**WEST SUSSEX COUNTY COUNCIL
STRATEGIC PLANNING CONSULTATION**

SUBJECT: A/89/14/PL - Erection of garage/workshop and an increase in height to the front boundary by 300m.

Downsview, Littlehampton Road, Ferring, West Sussex, BN12 6PW

SITE PLAN 1:500@ A4

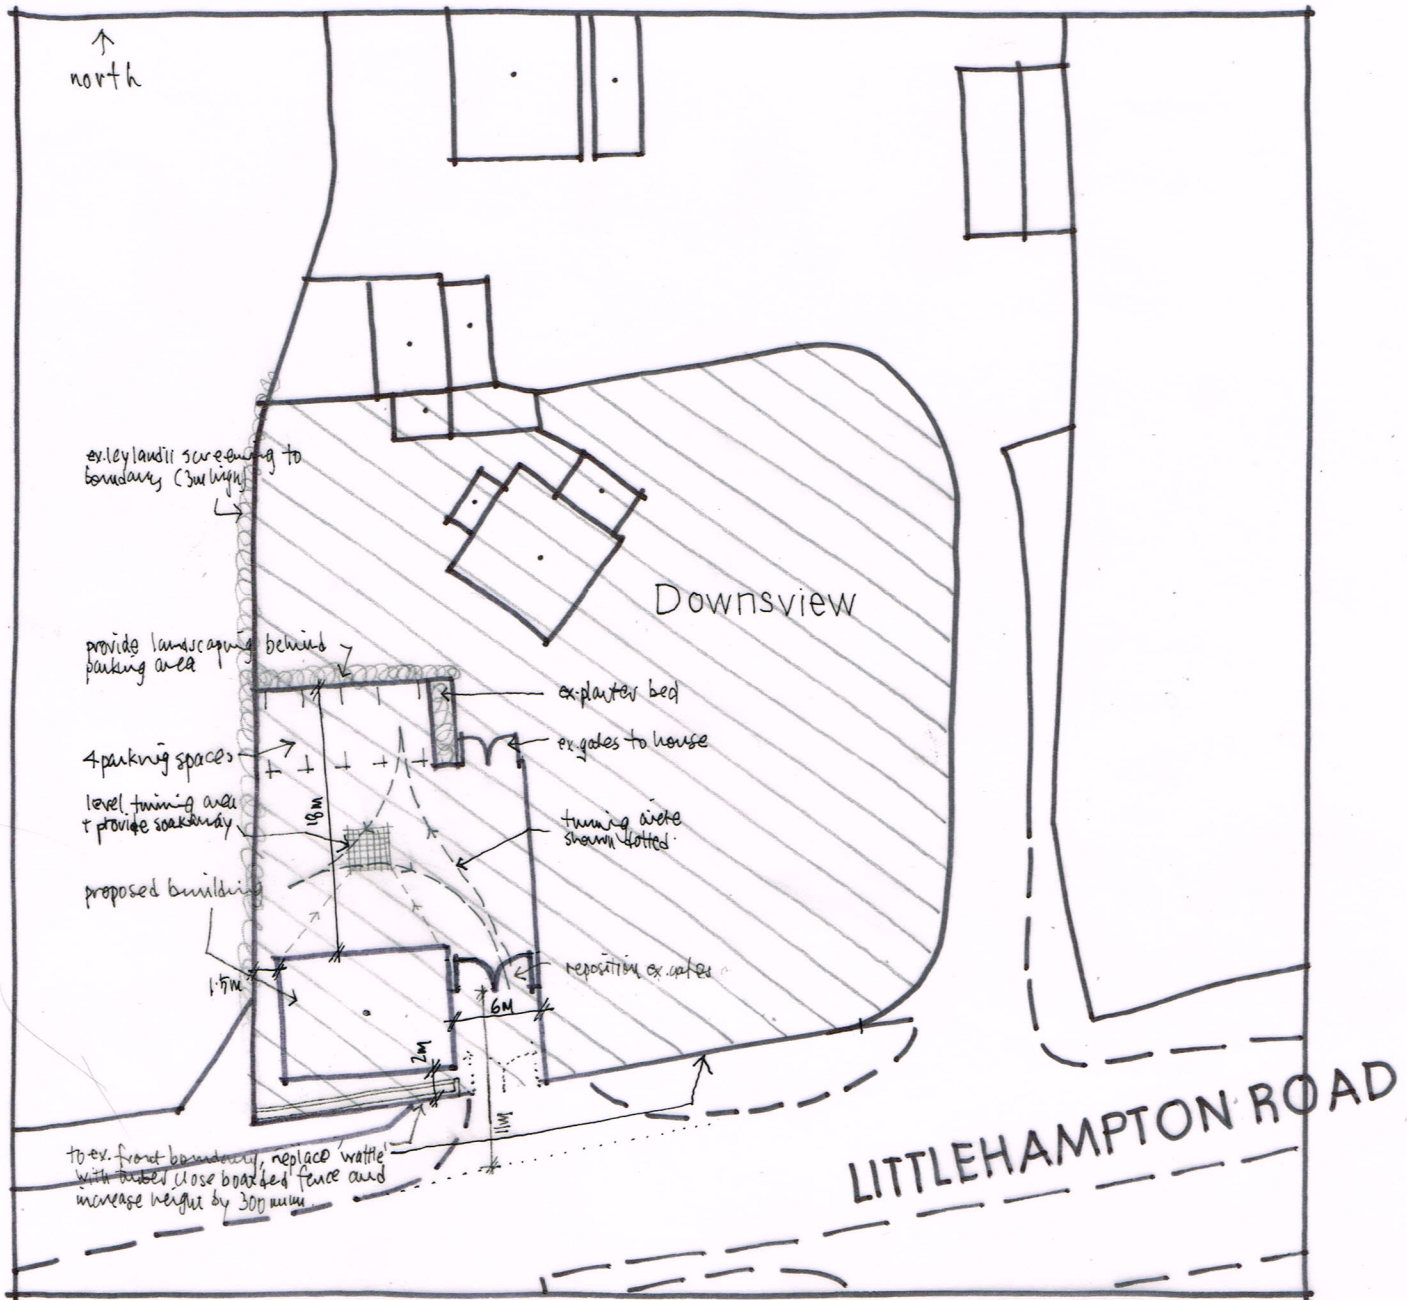
The existing point of access will remain, but it is proposed to set the gates, currently set back 5m, to 11m from the carriageway edge. This would allow a car towing a boat the clearance it needs to be safely off the highway if the gates are closed. The width of the access is wide enough to allow two cars towing a boat/or a car without a boat to pass each other.

The proposed parking allocation for 4 spaces seems reasonable. Standard parking spaces will be provided to store the boats either waiting to be repaired or waiting to be returned to their owner and should be 2.4m x 4.8m.

The increase height to the front boundary fence does not affect the visibility for a driver entering or exiting the driveway, as there is a good 5m hard standing outside the property before reaching the carriageway there is good forward visibility.

The gate shall be positioned at least 11m back from the edge of the highway in order that a vehicle may wait clear of the highway whilst the gate is being operated.

No part of the development shall be first occupied until the vehicle parking and turning spaces have been constructed in accordance with the approved plan. These spaces shall thereafter be retained for their designated use.
